REF 19/01177/F

Huw Jones of HVJ Transport is now on holiday and only had time to send me an email summarising our two meetings. Our District Councillor is also on holiday but has promised to see me on his return.

*Email from HVT Transport
18/10/11 77/F*

In my professional opinion and with over 40 years experience in this Transport Development field the proposed shared surface carriageway of South Side immediately outside your dwelling is clearly unsafe for the reasons shown below:-

Title : Proposed Pedestrian Facilities with Shared Space

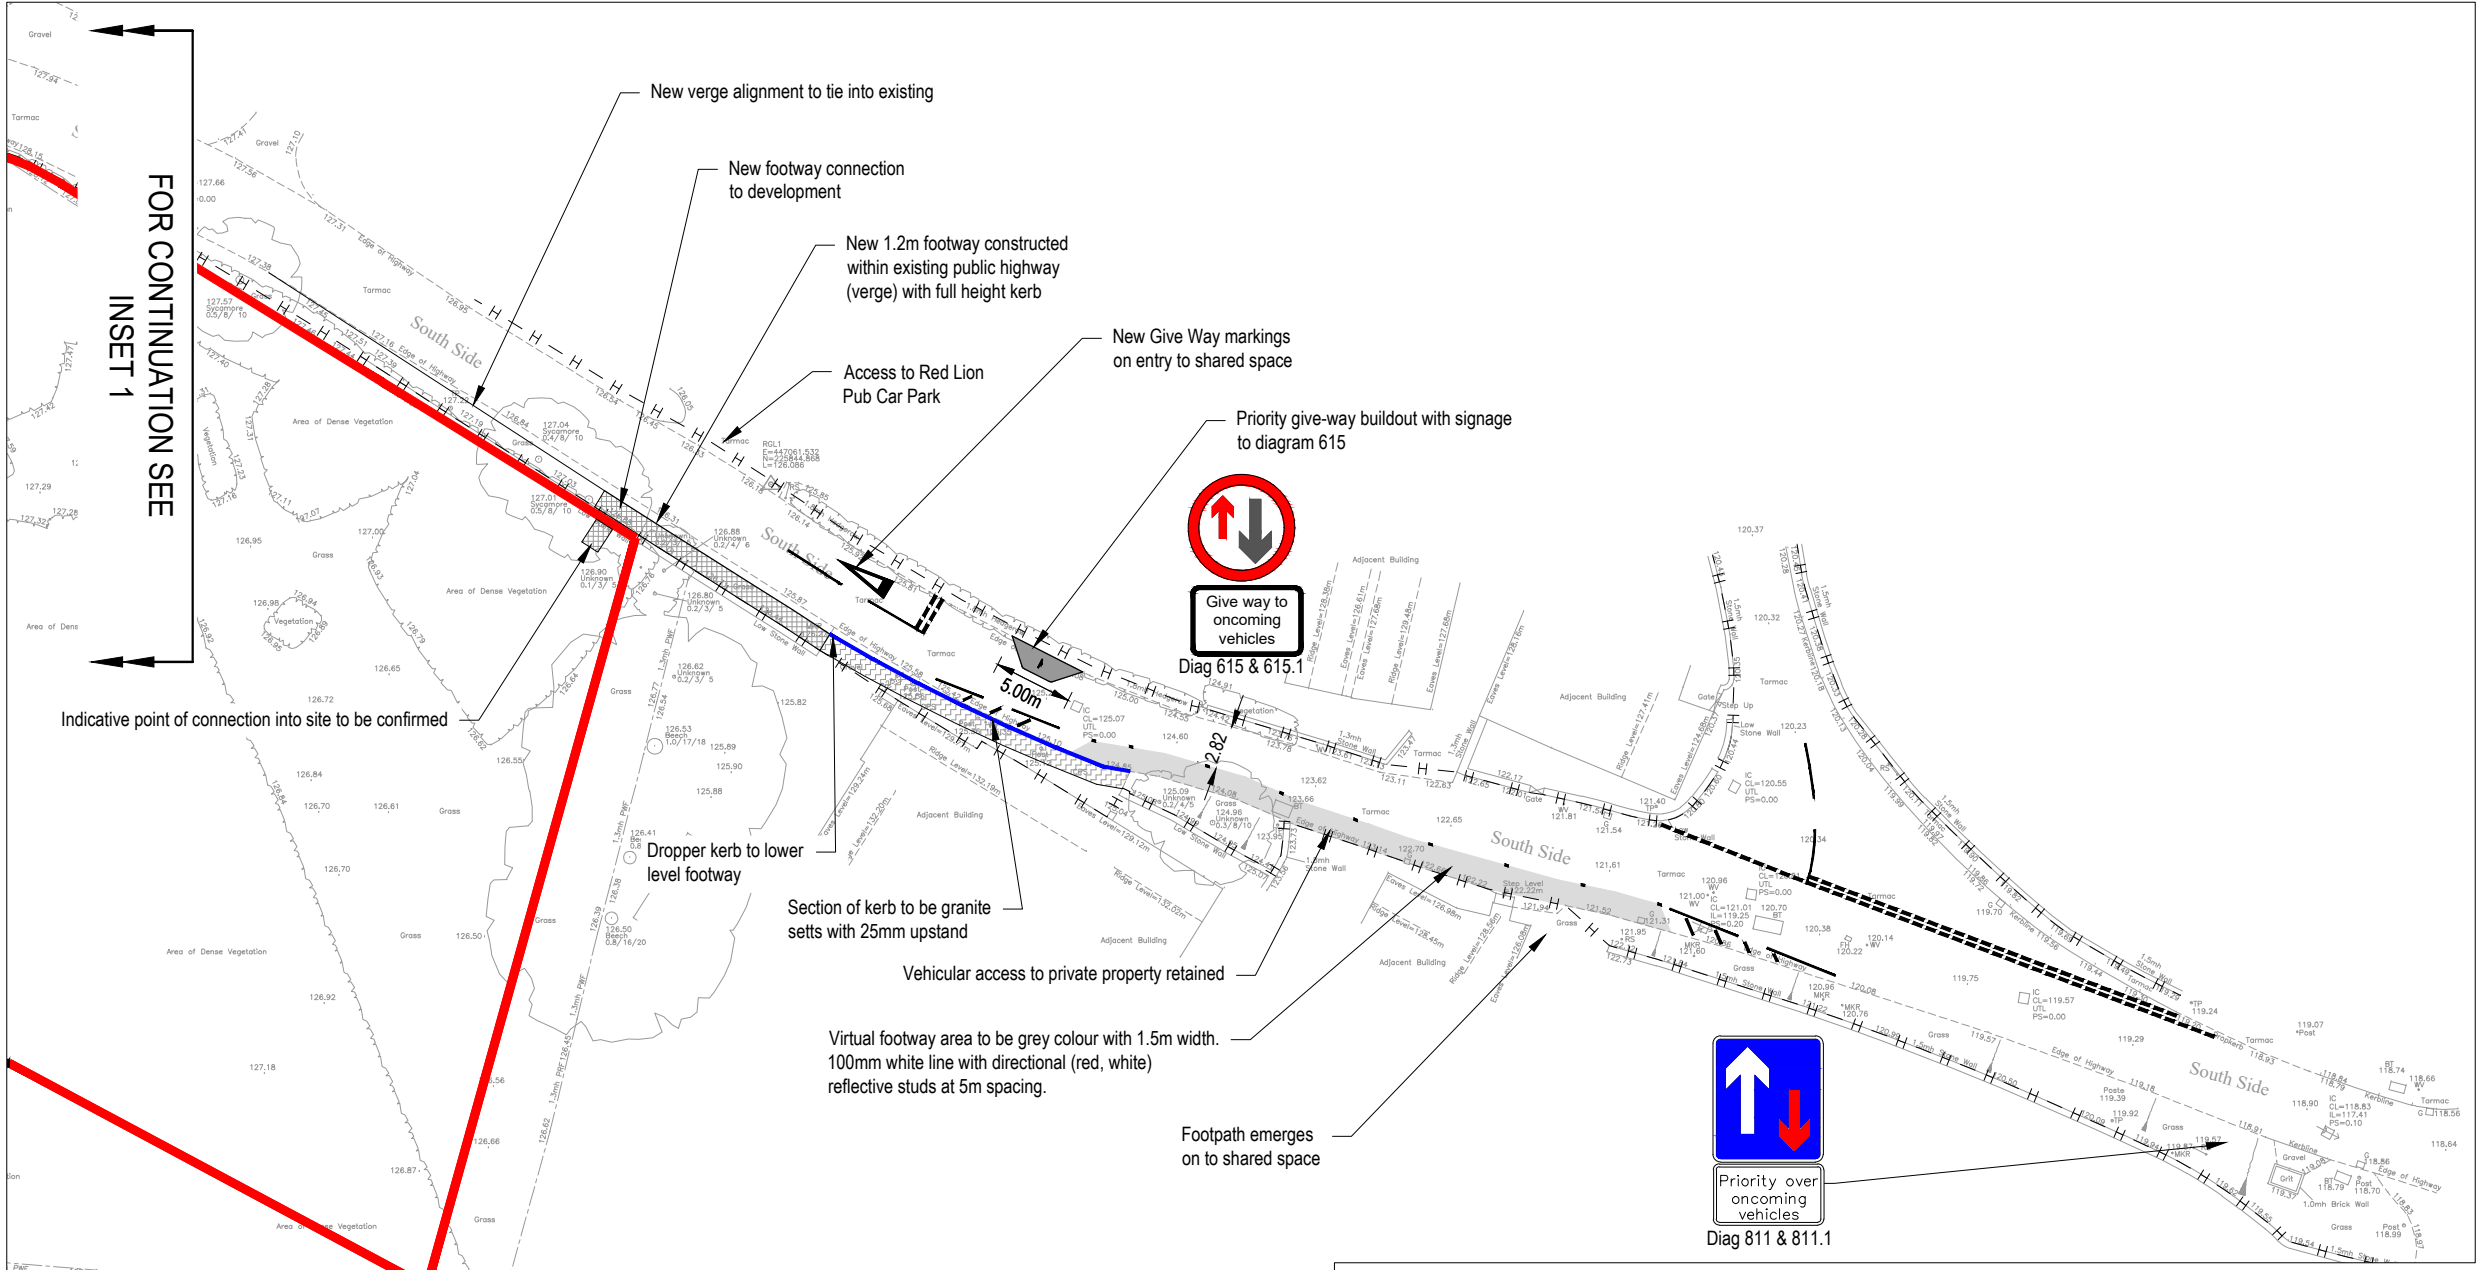
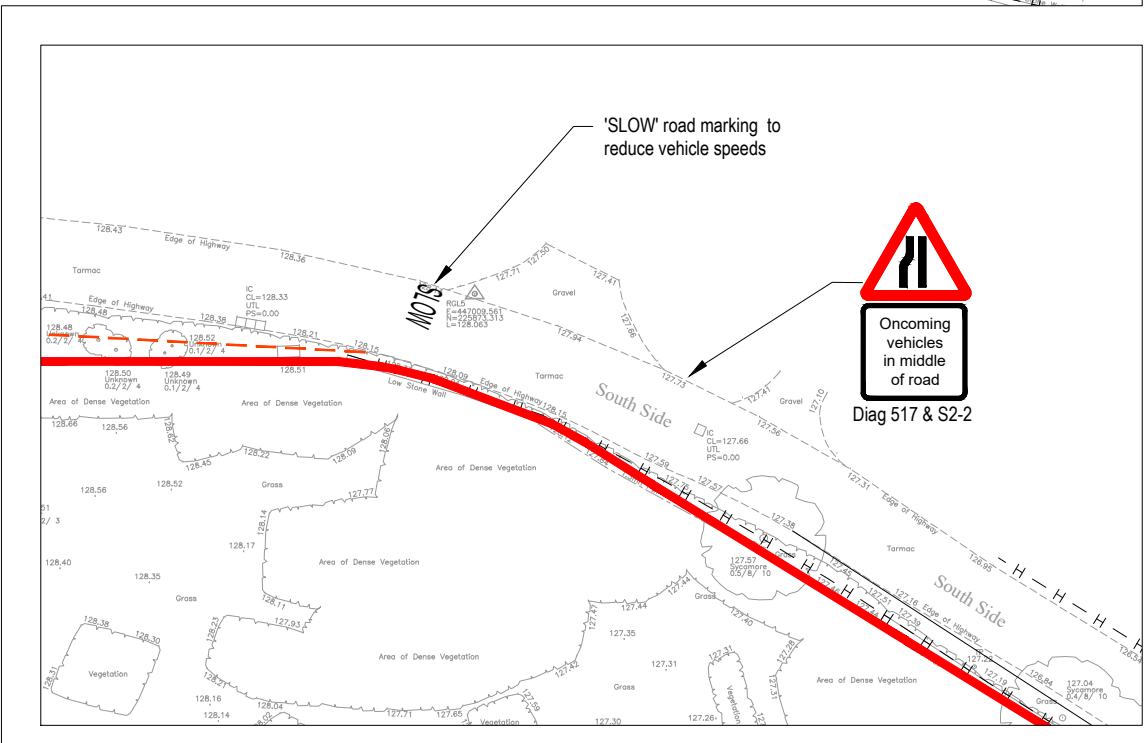
1. Forward visibility is impaired at the proposed build- outs due to the gradient in the carriageway and also the bend towards the A4260
2. Egress from the public house car park also interferes with the proposed build outs and the sightlines at this access are further compromised with no visibility

3. There are no links in terms of pedestrians safety where the shared surface links in with the footway near to the junction of Water Lane with South Side.

4. I am concerned regarding the pedestrian access point to your house which is also compromised by the proposed works to the adjoining public highway and in view of the many visits every week by your small grandchildren I am also worried regarding the safety aspects of them leaving the house straight in to the new proposed shared carriageway without any warnings or protected area

6. Furthermore the forward visibility towards the A4260 at the proposed build out and give ways etc are compromised even further by the setting of the sun etc

7. The proposed carriageway widths measured accurately by calibrated wheel show widths between 4.3m and 4.9m which are considered insufficient for 2 vehicles to pass each other and this is further compromised by the shared surface

The proposed build out will compromise road and highway safety at this particular sensitive location.
